Lime Down Solar Park

**Planning Inspectorate Reference:
EN010168**

Wiltshire Council Closing Statement

Deadline 8 (16 October 2026)

Data: IGP, 2025
Base map: © Crown copyright and database rights 2025 Ordnance Survey 0100031673.

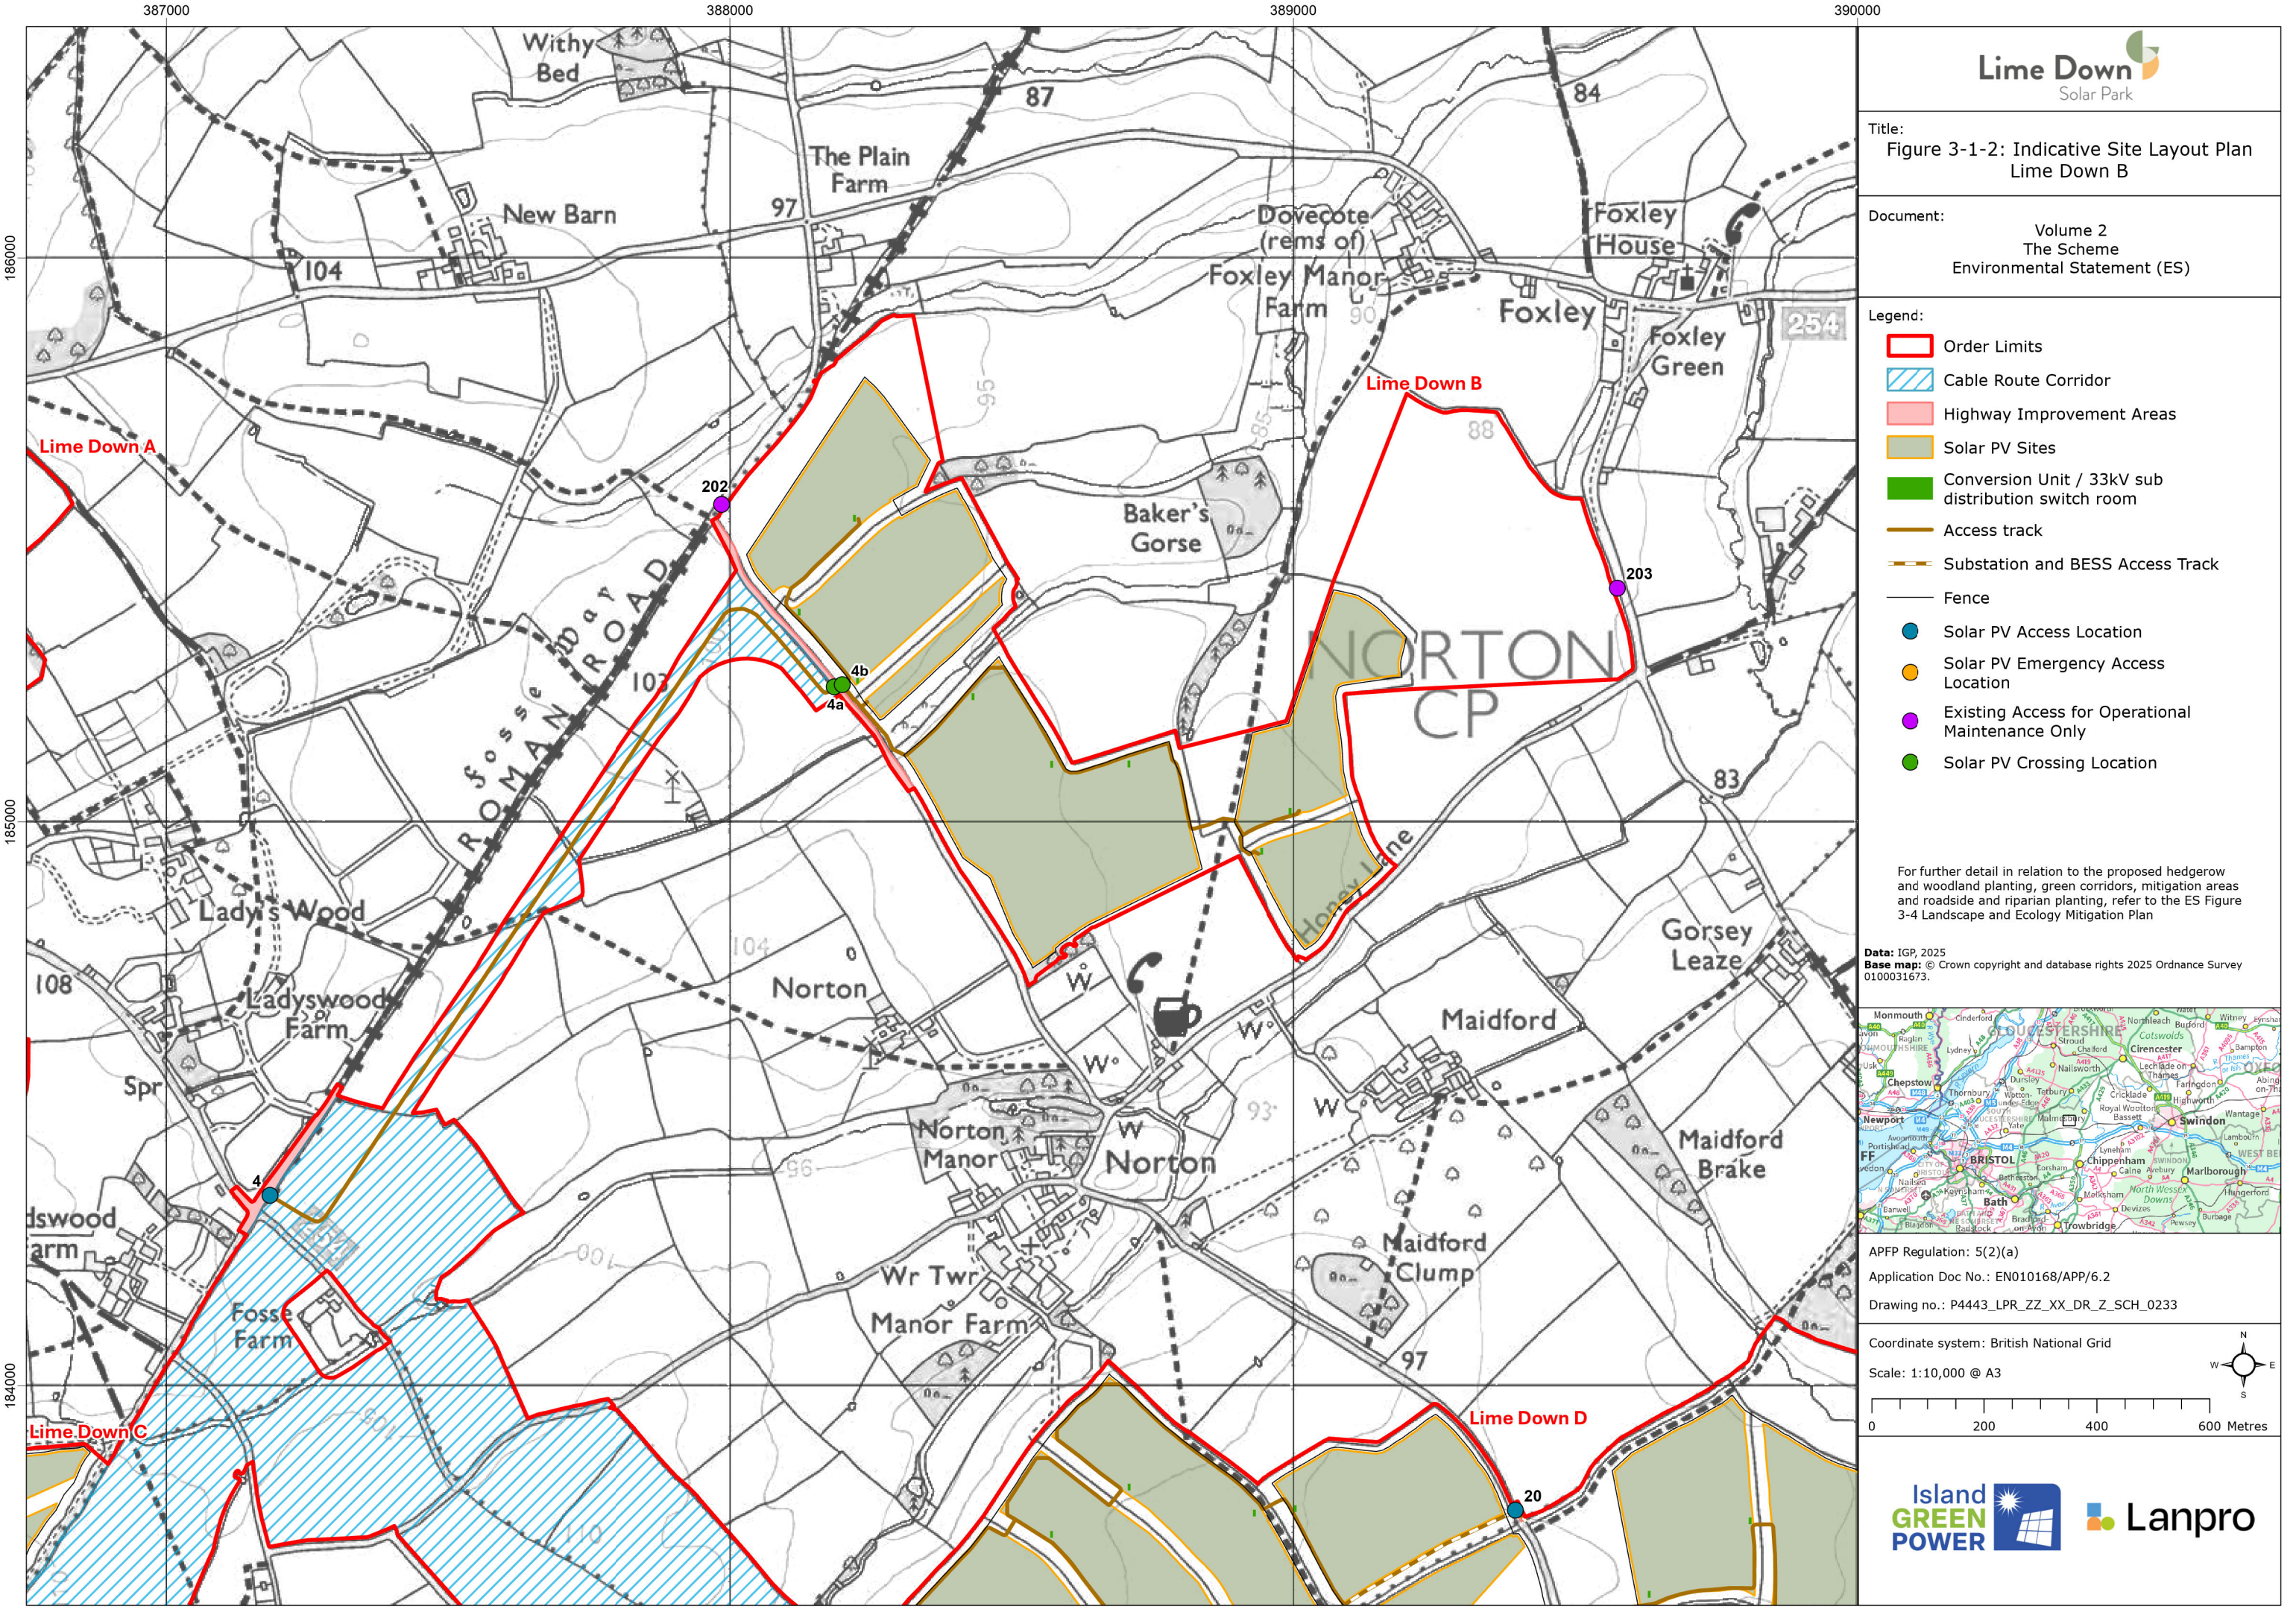
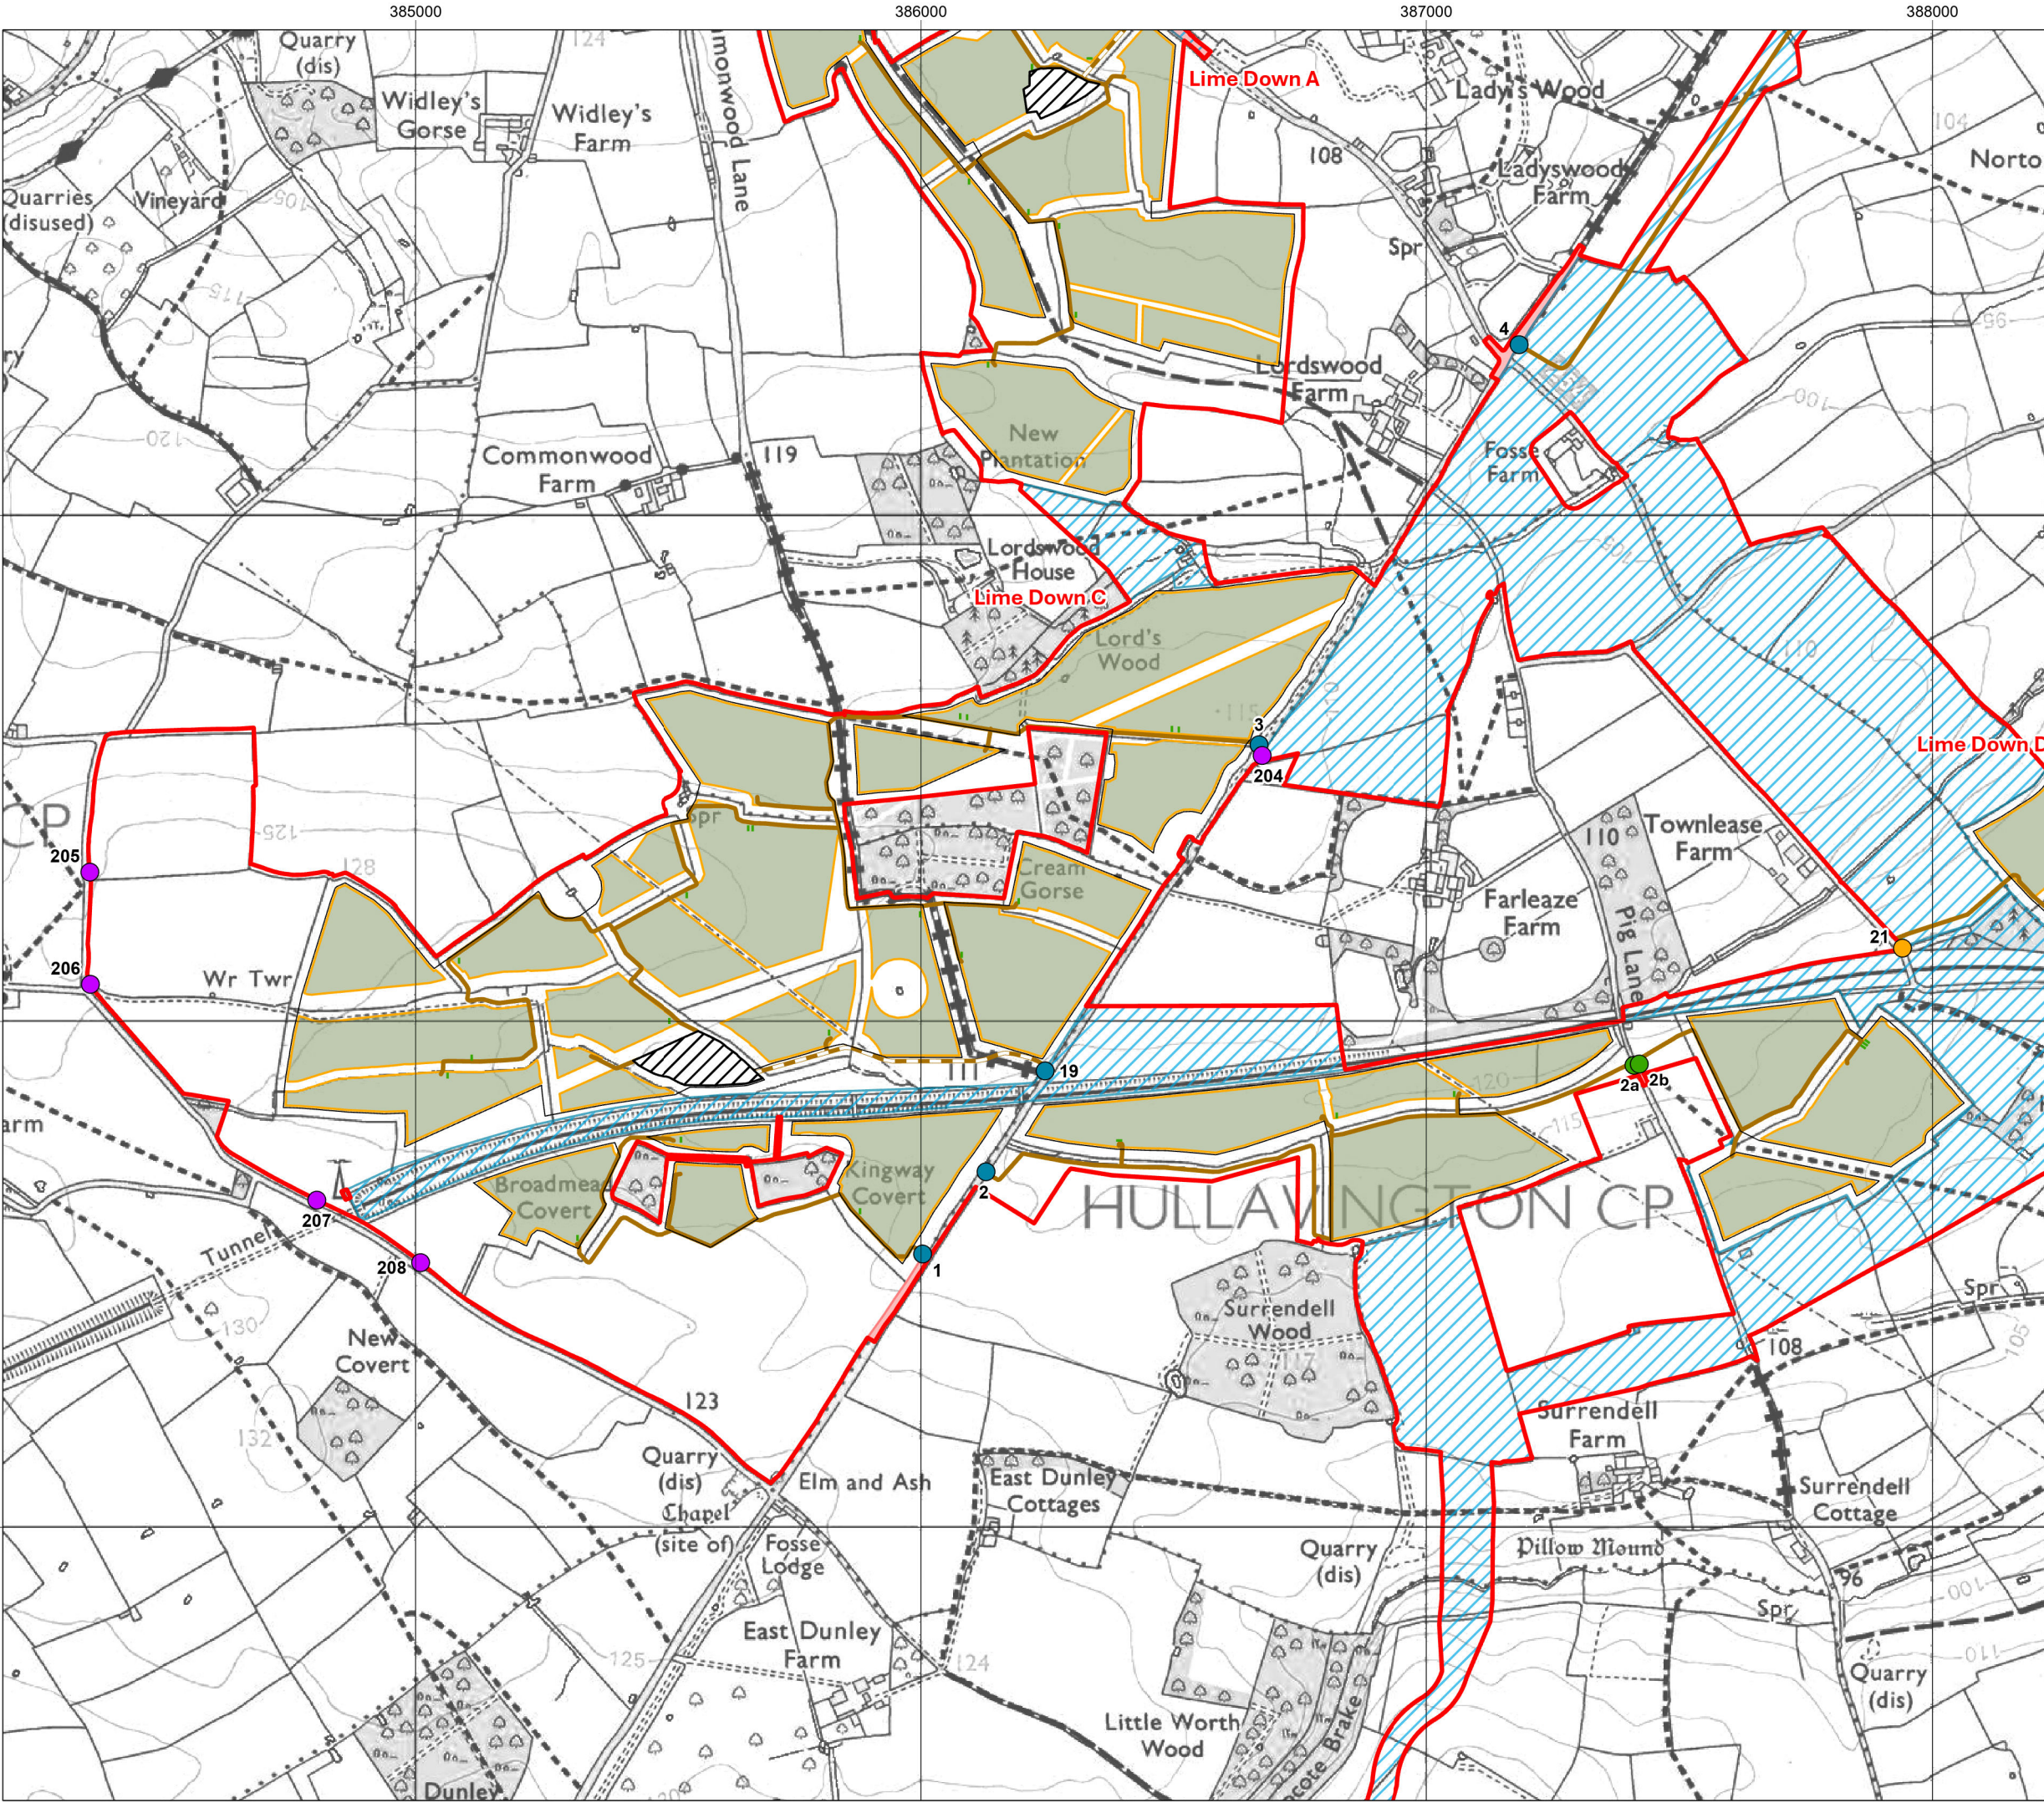
- 3.41. The council highlights that the figure still shows the southern part of Field A1 (Lime Down A) as a solar panel field area, despite its removal from the Landscape and Ecology Mitigation Plan (Rev 5) [[REP7-034](#)].

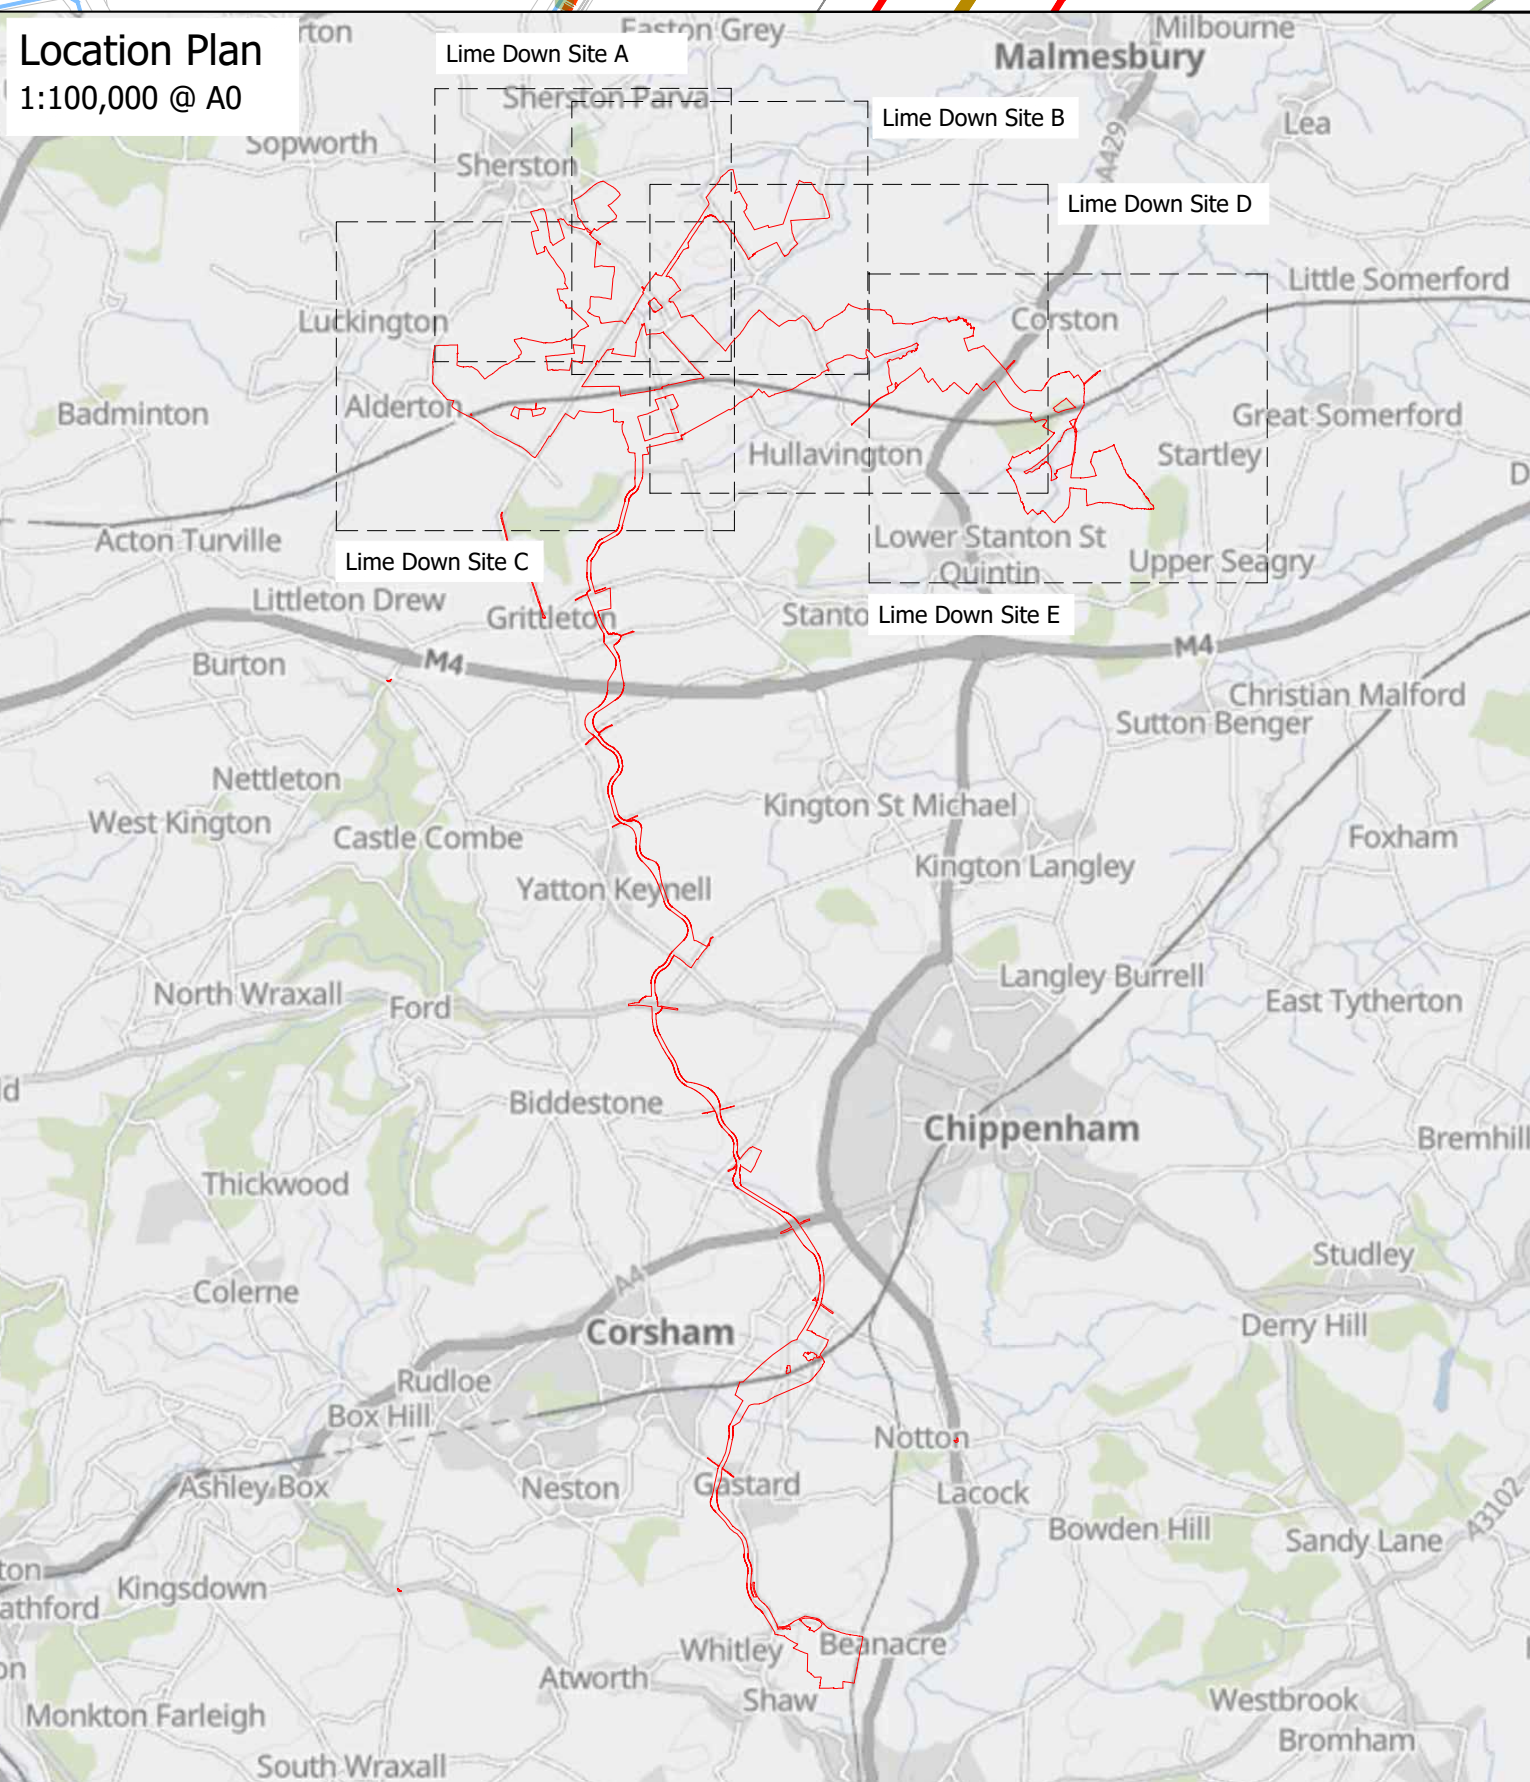
- 3.35. The council welcomes the Applicant's Deadline 7 revised submission which now better illustrates on the drawings the different construction types and uses of the proposed internal access tracks, and more clearly identifies the location of the drystone walls that are proposed to be retained and restored and illustrates the removal of panels from southern part of Field A1 (Lime Down A).

- 3.37. The latest version (Rev 7) of the draft DCO (dDCO) [\[REP7-007\]](#) does not secure any obligation or requirements to update the Landscape and Ecology Mitigation Plans following the detailed design of the scheme. While it is understood that Schedule 2 of the dDCO includes the Requirement for submission of a written detailed 'Landscape and Ecological Management Plan' (LEMP) for the LPA's final approval as prescribed by DCO Requirement 7, which must be substantially in accordance with the outline LEMP, and a Requirement for submission of a written 'Ecological Protection and Mitigation Strategy' (EPMS) for the LPA's approval as prescribed by DCO Requirement 8, also under Schedule 2, which must be substantially in accordance with the outline EPMS, it is clear that both of the above DCO Schedule 2 Requirements
